Recommendation: Refuse

Applicant: Mr Geoffrey Richard Noquet

Proposal: Permission is sought to re-position and amend the structure of the previously allowed 3 bedroom building

SKETCHED VIEW FROM STREET THROUGH BURDROP

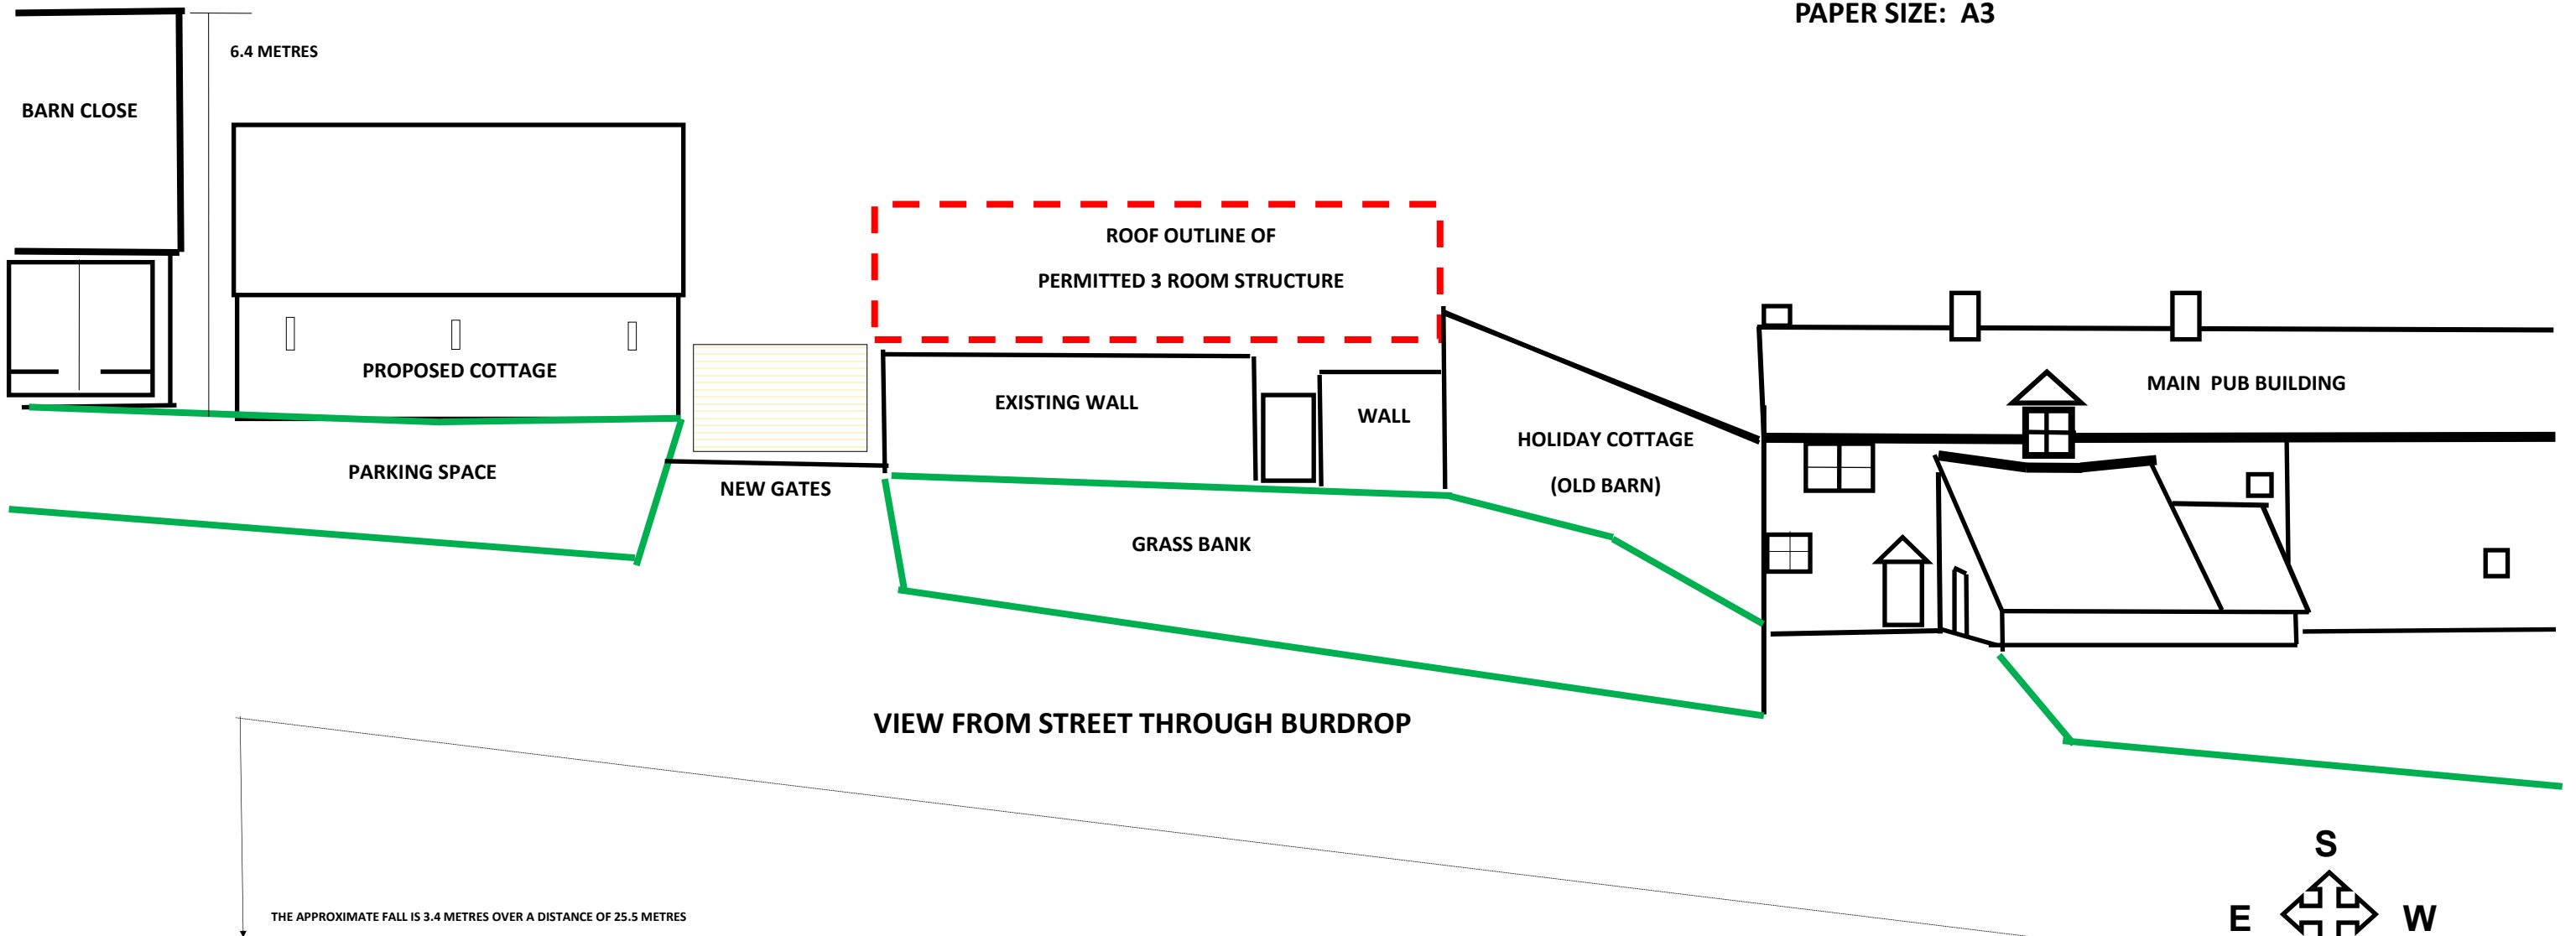
- 8.13. As highlighted above, works on the appeal approval has, according to the applicant, commenced which means that this approval is a material consideration, and the applicant could continue with these works and complete the single storey accommodation. The current proposal for the two-storey accommodation would then need to be viewed alongside the appeal approval. The development of both schemes would effectively reduce the gap between the pub and Barn Close as shown on the applicants block plan. This point was raised in the appeal decision where the Inspector in allowing the appeal the Inspector highlighted that the appeal proposal would not *close the gap between the Public House and neighbouring buildings in a harmful way. The Public House would still appear as a building on the edge of Burdrop slightly separate from the rest of the village.* By closing this gap, the proposed accommodation would reduce the openness on the site changing the character of this part of the village and the Conservation Area.

- 8.15. Notwithstanding the above the design and external appearance of the proposed holiday cottage also needs to be considered. Although the applicant states that this proposal seeks permission to re-position and amend the structure of the previously allowed 3 Bedroom Building it is clear that the in terms of design and appearance the current proposal is a significantly different proposal. The as approved scheme is a single storey structure with three separate accommodation rooms each with en-suite facilities. The current proposal as an amendment is for a larger building and with accommodation within the roof space would be two storeys in terms of scale. The current proposal in terms of footprint is also larger than that of the appeal proposal now proposing a projecting rear wing to allow for the accommodation in the

building. In terms of appearance this current proposal appears more as a domestic / free standing structure which due to the significant slope gives the appearance that the building is separate to the public house.

- 8.18. Due to the domestic design / appearance of the cottage the proposal and it's location the building would not appear as an ancillary structure to that of the public house. The design results in a building which appears as a freestanding property separate to that of the public house to the detriment of the character of this part of the Conservation Area. This is very different to the as approved smaller single storey accommodation approved under the appeal. Then location, simple design and lower height of the as approved building would have a lesser impact on the area and the street scene appearing as the inspector pointed out as a natural extension to the pub and as an ancillary building.

1. The proposed cottage, by reason of its prominent siting, scale and unsympathetic appearance is considered to be inappropriate development within the context, appearing as an incongruous feature within the street scene causing undue harm to the character and appearance of the Sibford Gower and Burdrop Conservation Area, the setting of the public house, a non-designated heritage asset, and, together with the approved single storey holiday let, would close the feature gap between the public house and Barn Close disrupting views through to the surrounding valued countryside. The public benefits of this proposal do not outweigh this harm. The proposed development is therefore contrary to Policy ESD15 of the adopted Cherwell Local Plan 2011-2031 Part 1, saved policies C28, C30 and C33 of the Cherwell Local Plan 1996, and Government guidance contained within the National Planning Policy Framework.
